# CITY OF ALBUQUERQUE

March 20, 2019

**RE: Lot 7 Block 10 Unit 22 Volcano Cliffs SAD 228  
6408 Petirrojo NW  
Grading and Drainage Plan  
Engineers Stamp Date 2/15/19 (D10D003F7)  
Pad Certification Date 2/15/19**

<div>ENGINEER'S SEAL</div> <div></div> <div>DAVID SOULE P.E. #14522</div>	6408 PETTIRROJO	DRAWN BY WCVJ
	GRADING AND DRAINAGE PLAN	DATE 2-13-19
	<div>Rio Grande Engineering 1606 CENTRAL AVENUE SE SUITE 201 ALBUQUERQUE, NM 87106 (505) 872-0999</div>	219008-LAYOUT-2-13-19
		SHEET #
		JOB # 219008

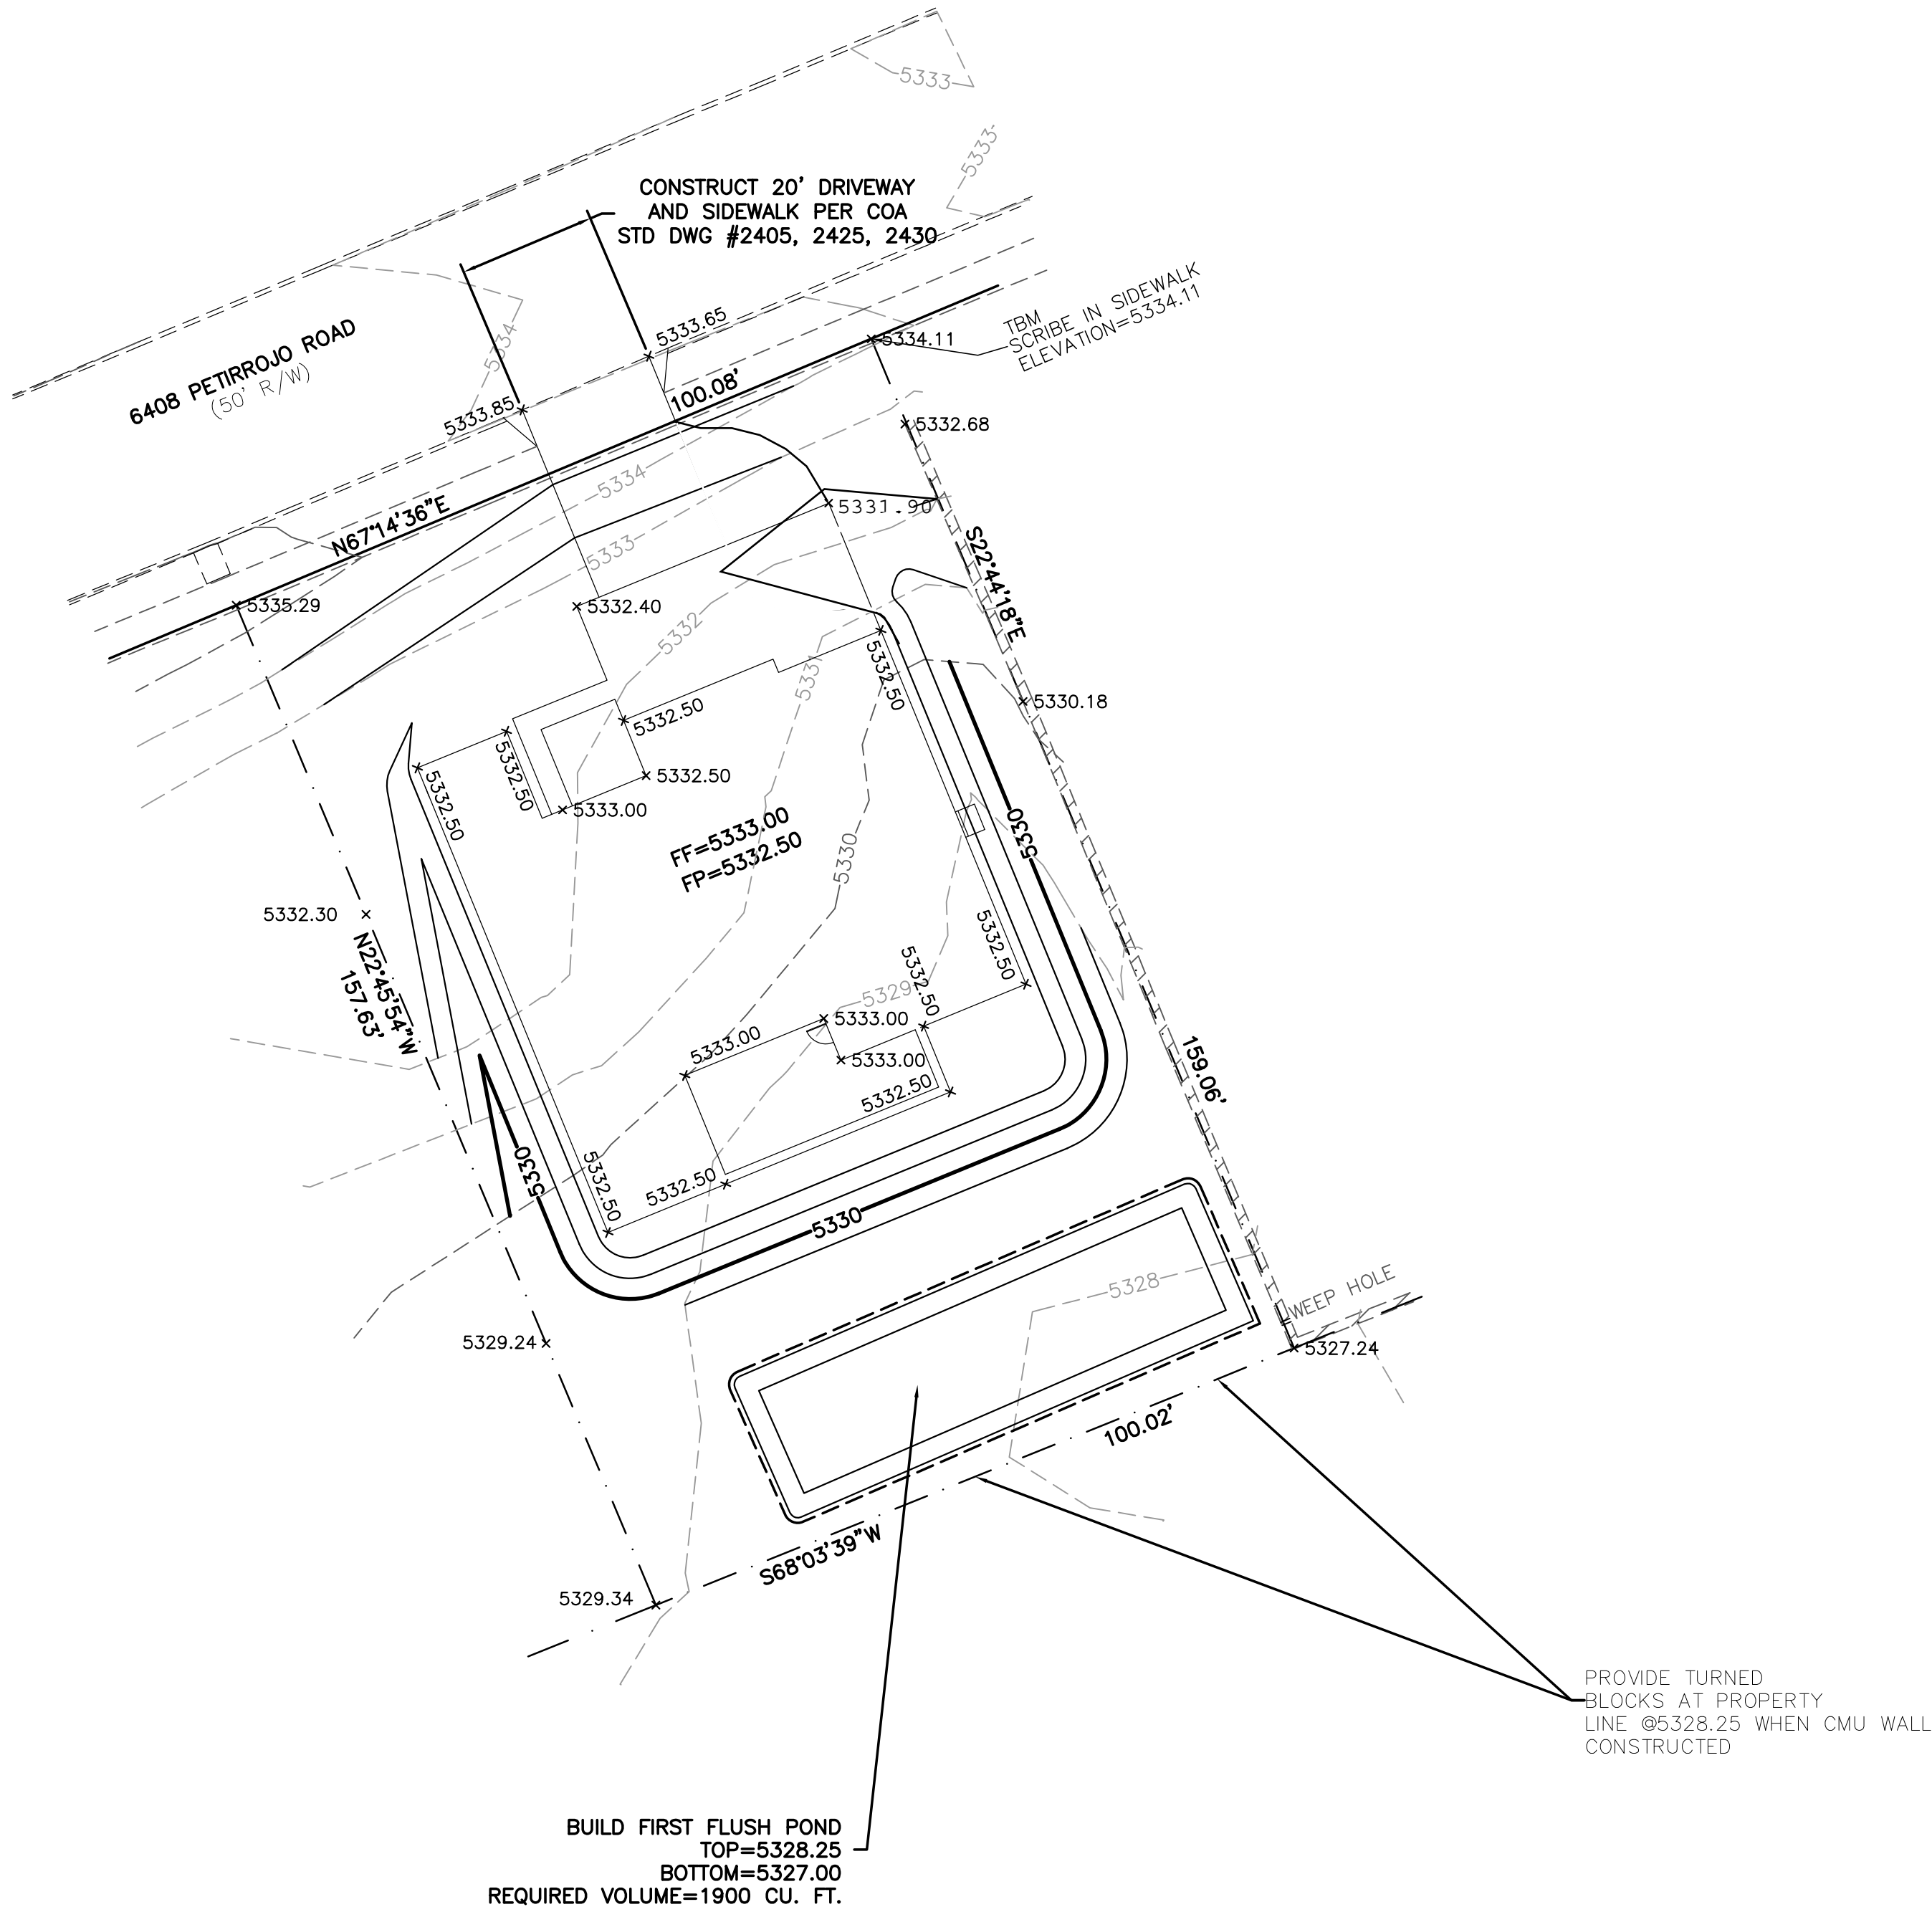
- Remove the dirt from the street being used as a ramp.
- Remove dirt piles on the sidewalk.
- FF and FP seem to be 3-4 feet lower than the street elevation, provide accurate FF-FP elevations.
